Householder Proforma

Application Ref: 2022/0227

Address: Holly Bank, 37 Cone Lane, Silkstone Common, S75 4PX

Recommendation: Approval with conditions

FRONT ELEVATION
AS PROPOSED 1:100

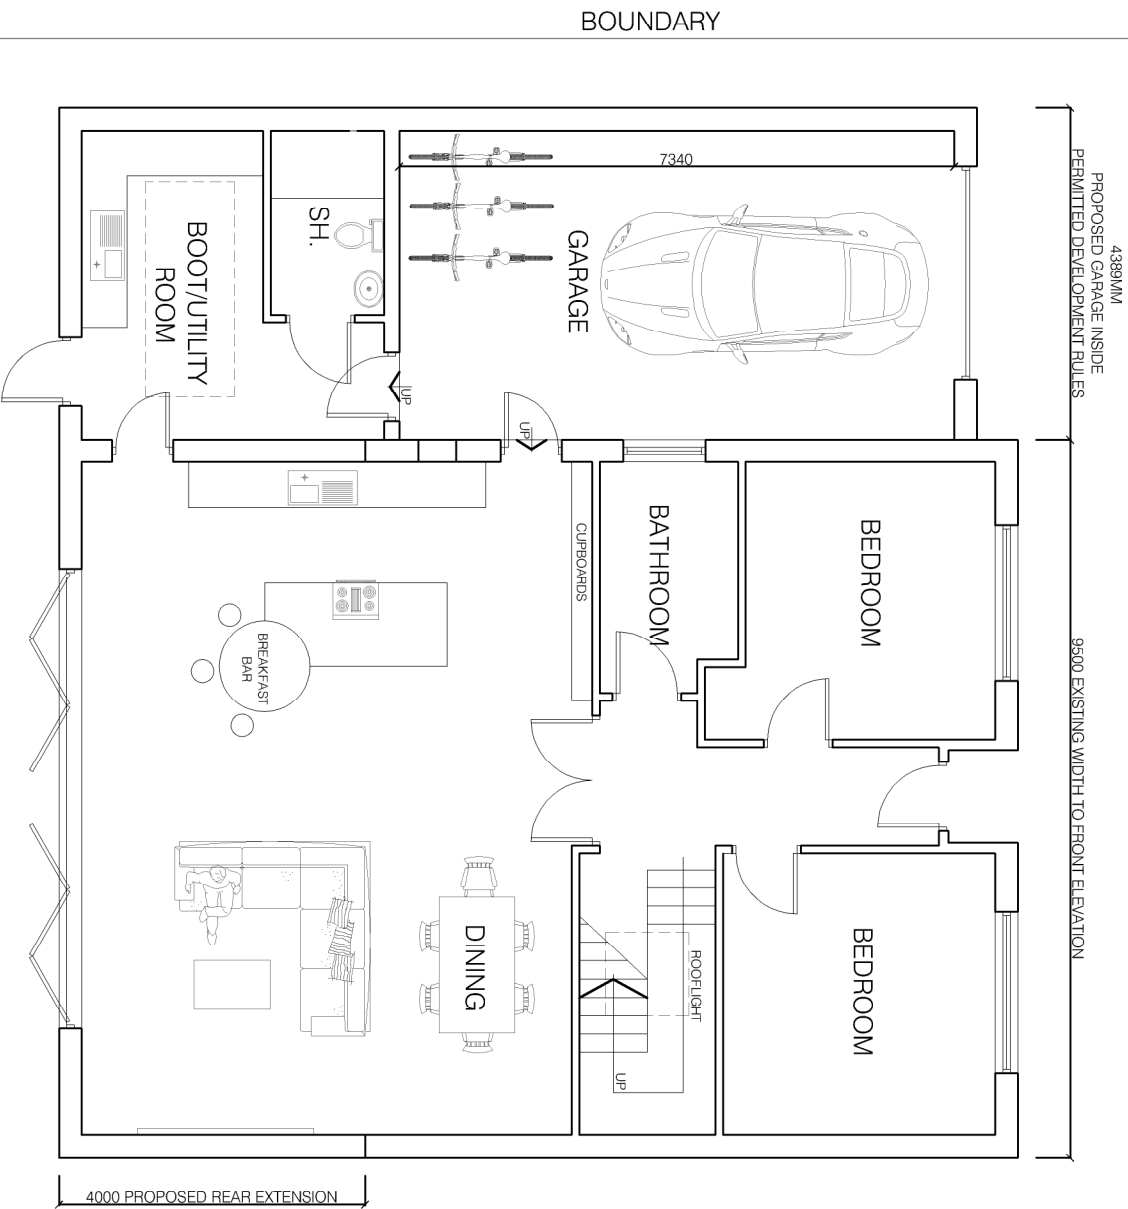
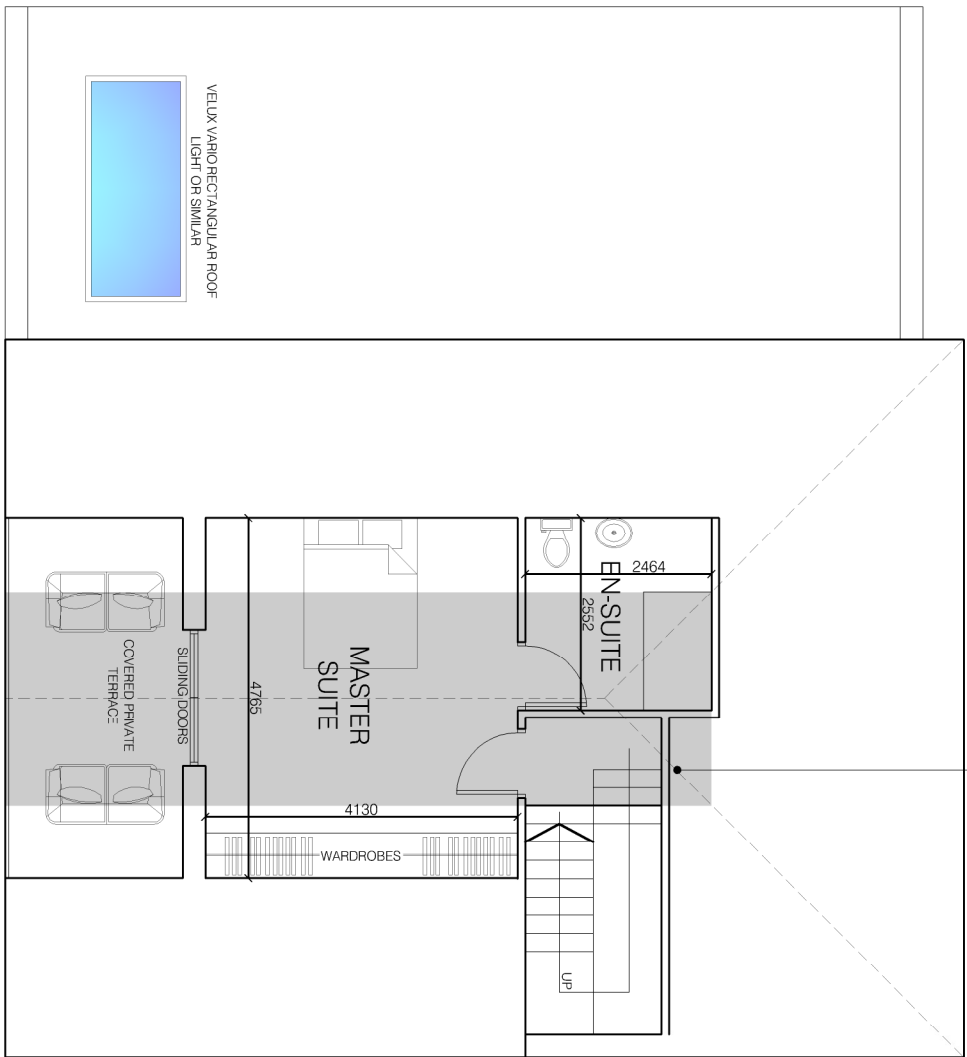
4. roof design corresponds to existing	No, it is proposed that the side extension is a flat roof, although this is not an uncommon feature within the area and will replace a flat roofed detached garage.

5. windows / doors of a similar design / proportion	No windows proposed for the side extension, only a roof light to the rear.
6. habitable room windows on the side elevation	No

The proposal is to raise the roof height by approximately 0.3m and change the rear roof arrangement from hip to gable. The property is located on Cone Lane which has a sloping gradient with 2 storey properties flanking the site. Cone Lane has a mix of properties in design and height along both sides of the highway. The height of the proposed roof within this location is not expected to look out of place, nor have an overbearing impact to the neighbouring dwellings in line with Planning Policy.
